V1_Drainage Letter_comments.pdf Markup Summary

Amo Acres Subdivision

Final Drainage Report

PCD File No: **SF2623**

DRAINAGE MAP

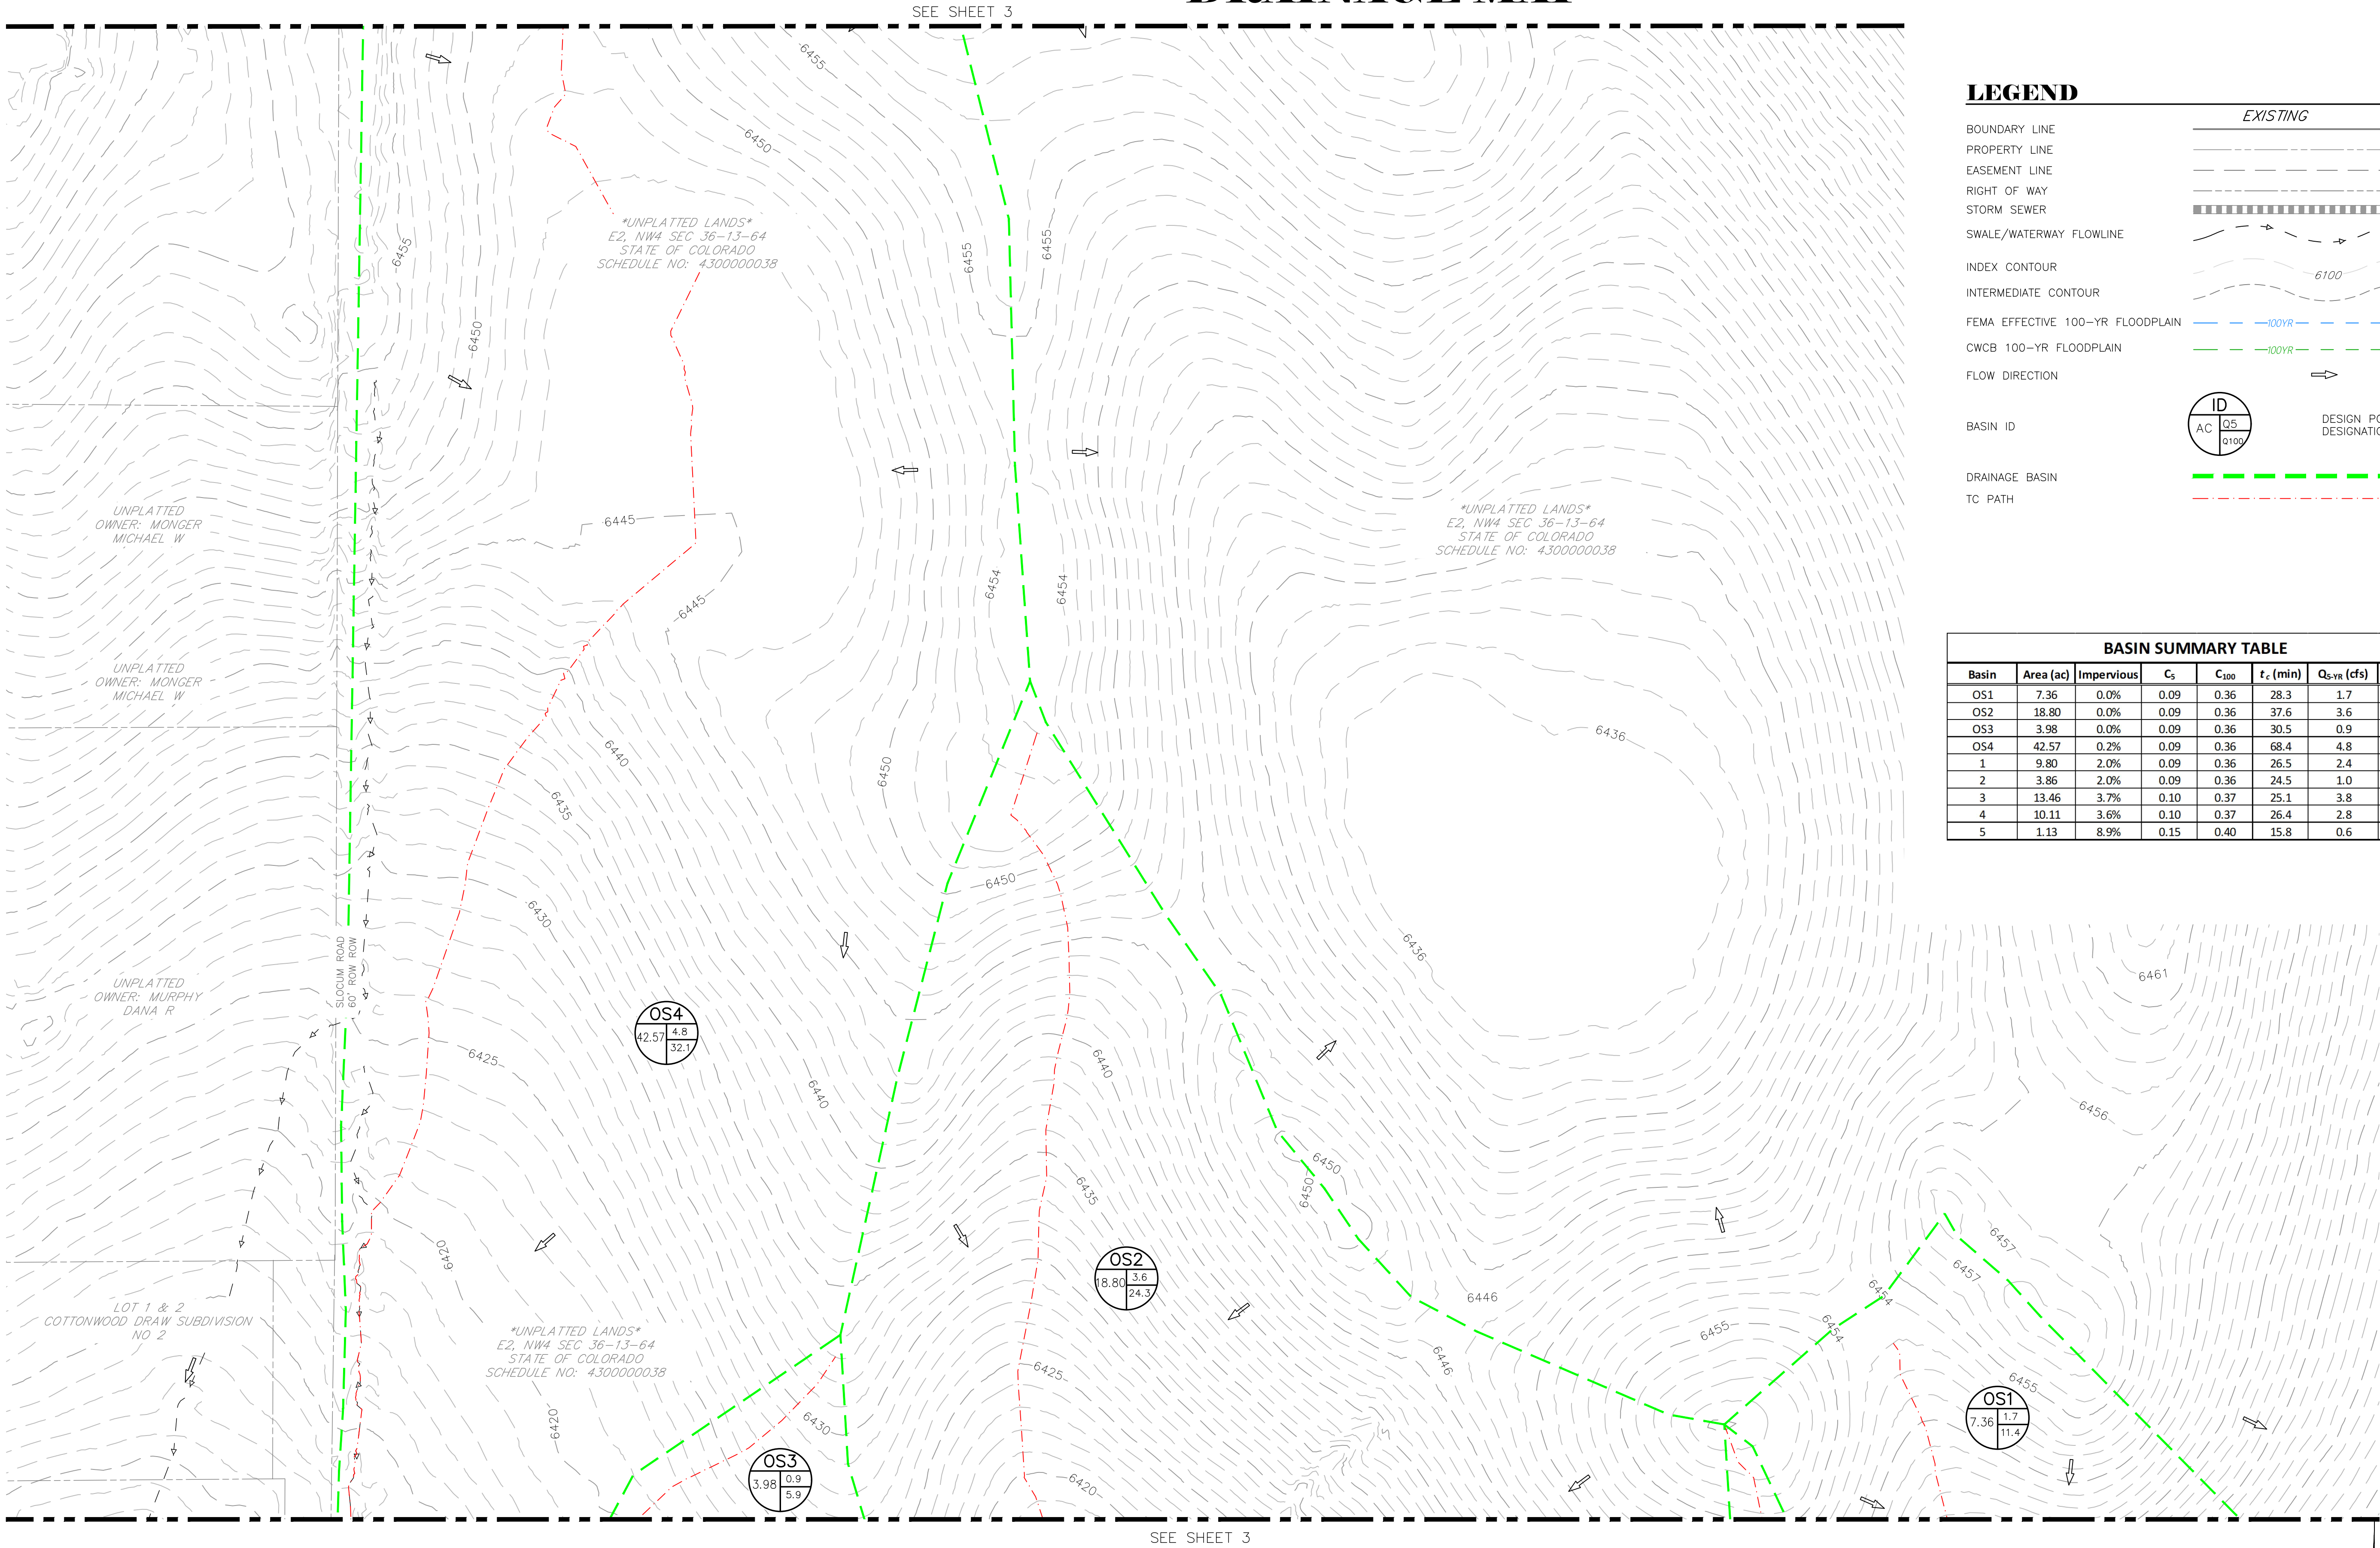
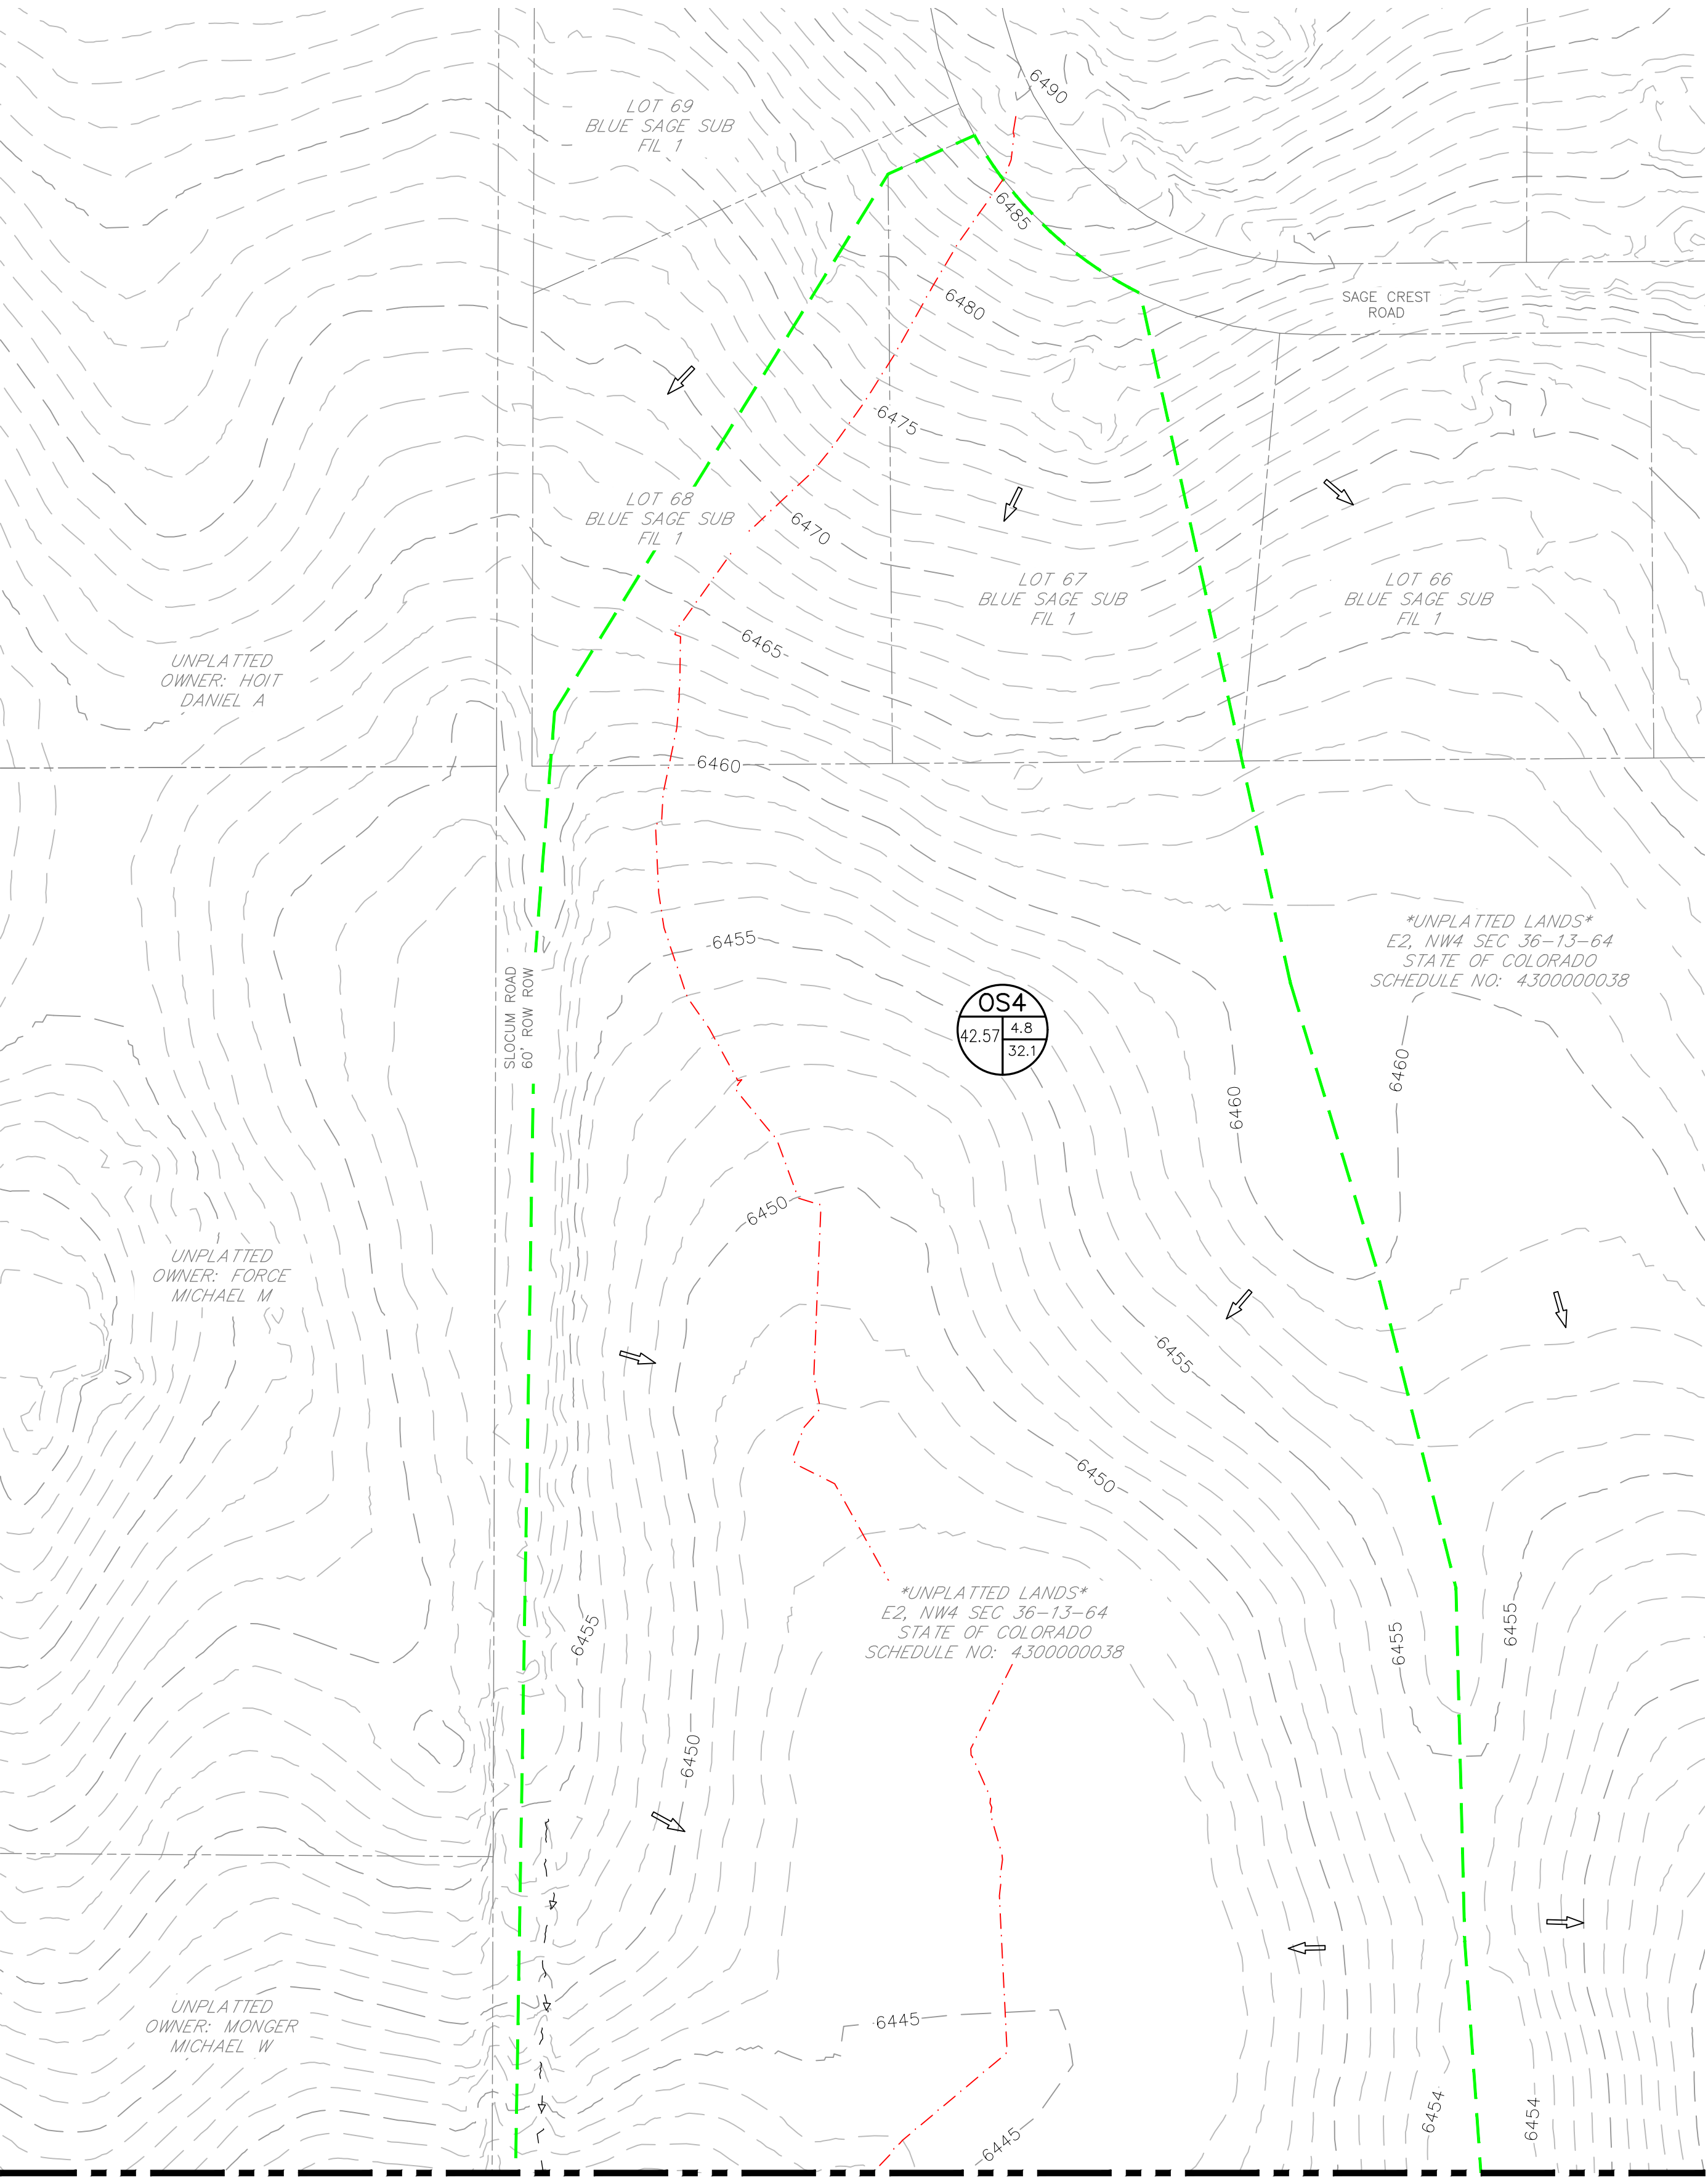
Please verify this value, is it 10.53 from pdf page 34 of 36.

Please verify this value.

What are you going to do about this over topping?
